Please ask for: Ms Iqraa Malik
Email: iqraa.malik@terraquest.co.uk
Telephone: 0121 234 1390
Our Ref: FG/197/21/HH
Your Ref:
Date: 1st November 2021

Application for Planning Permission for Works or Extension to a Dwelling

Development: Erection of single storey front and rear extension following the demolition of garage
Location: 12 Clover Lane Ferring BN12 5LZ

Drawing Title
Existing & Proposed Ground
Block Plan

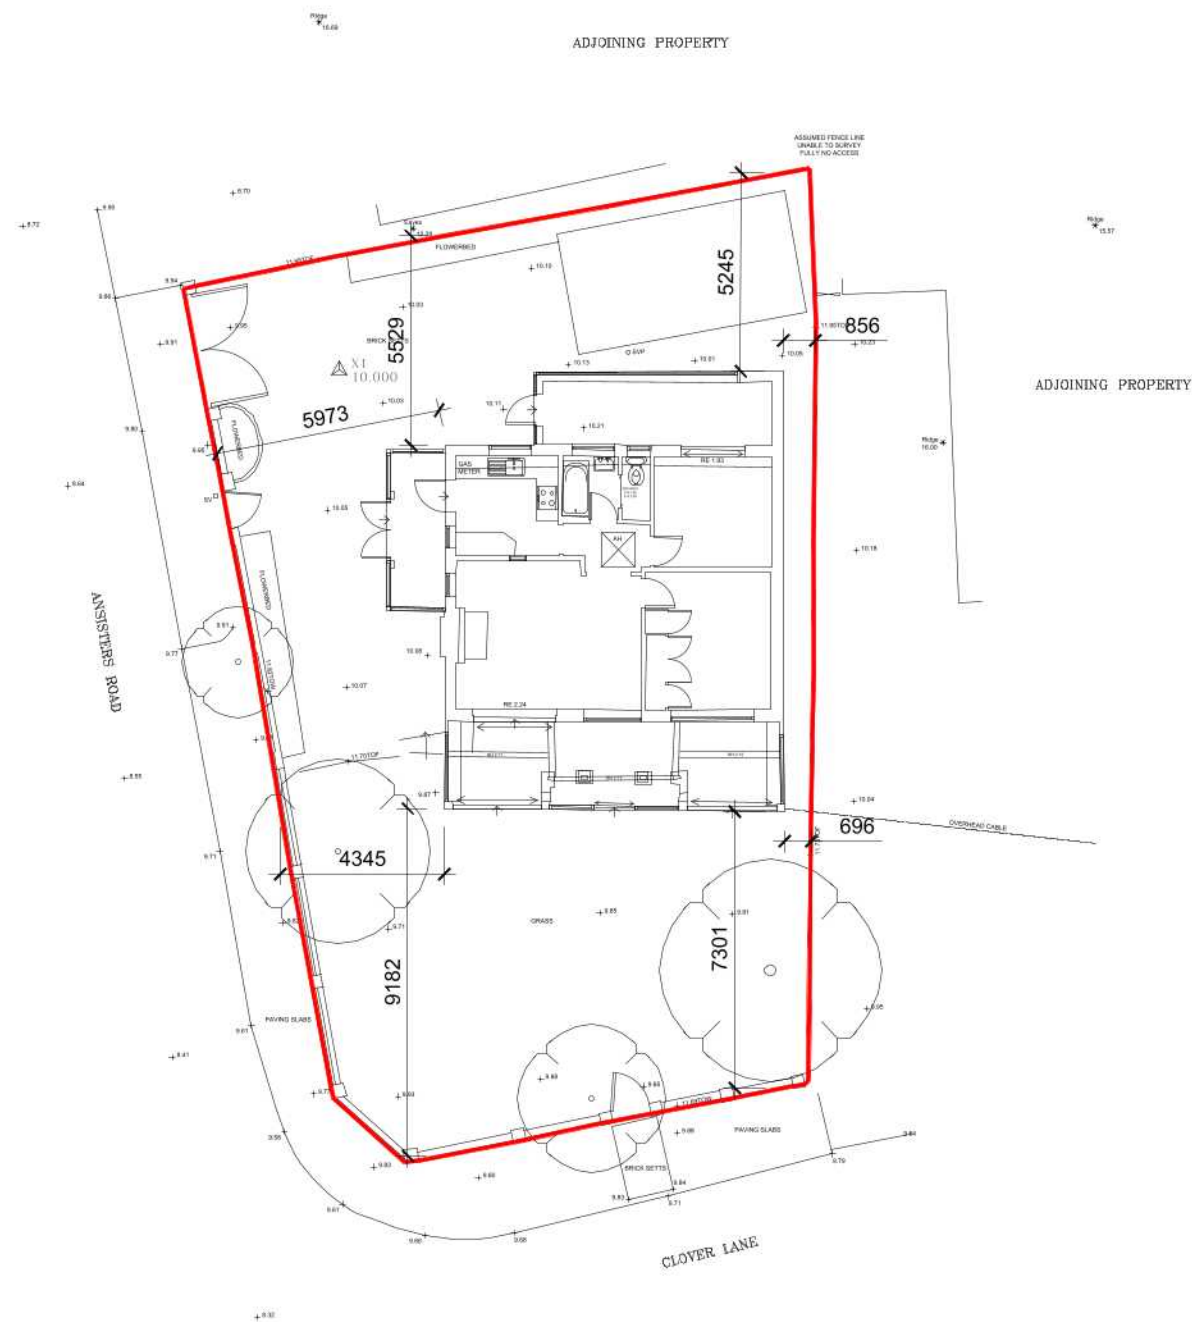
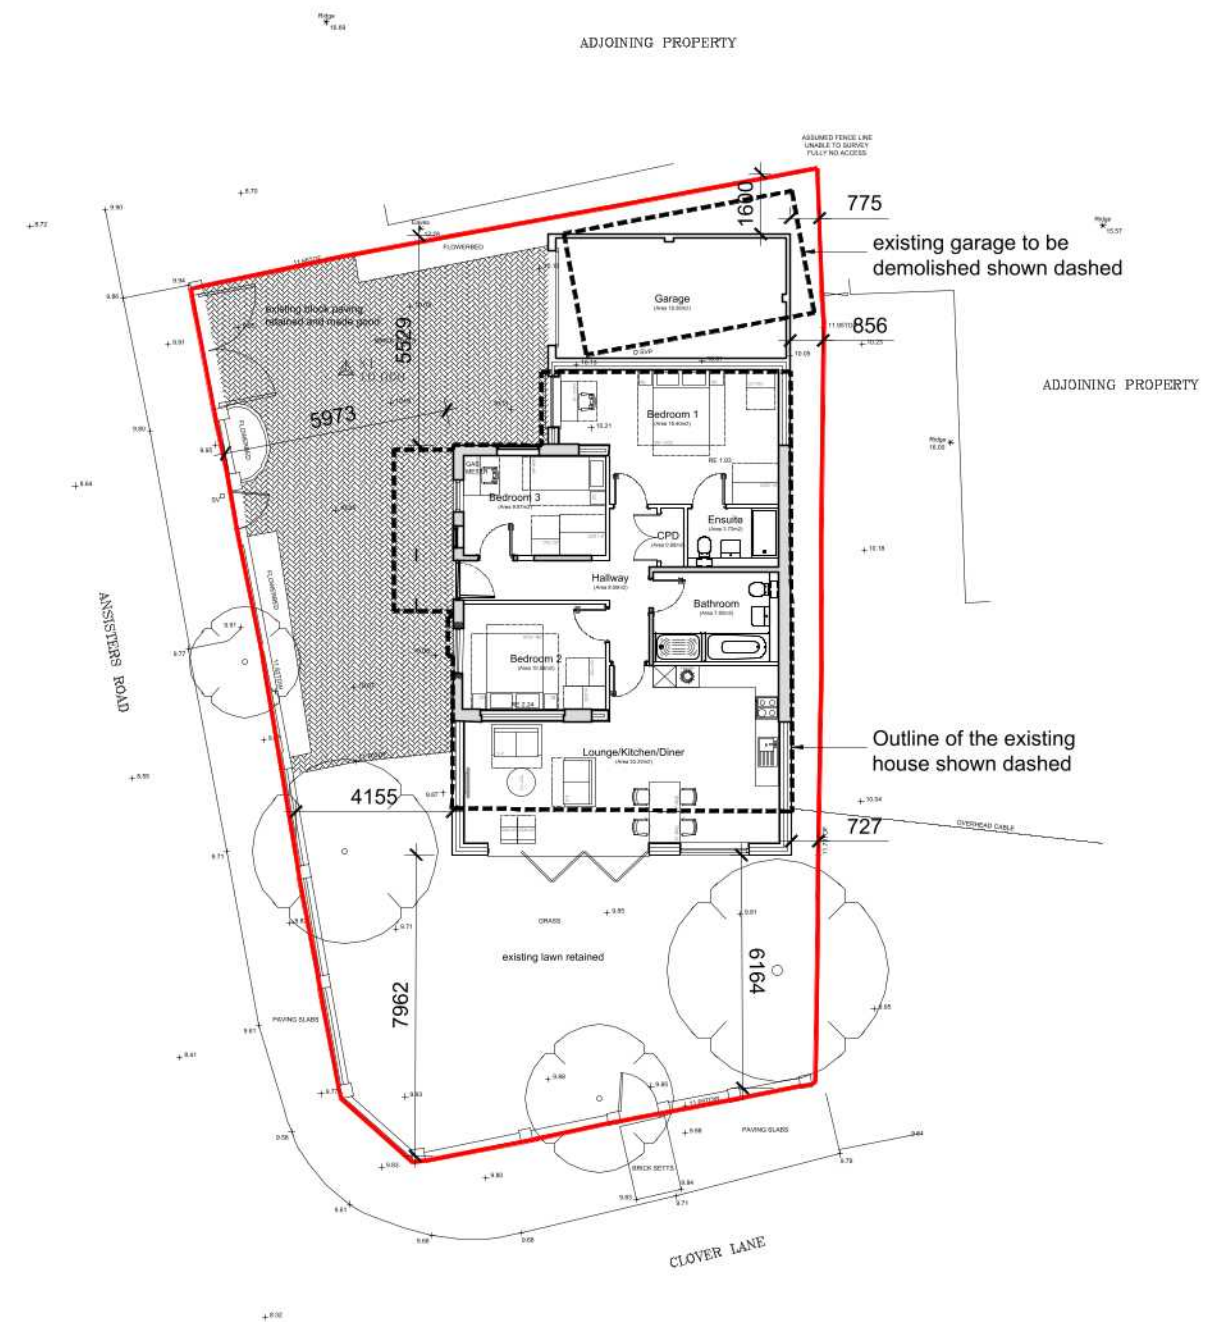
Block Plan

You are required to have dimensions from the proposed extension(s) to all site boundaries. Please amend.
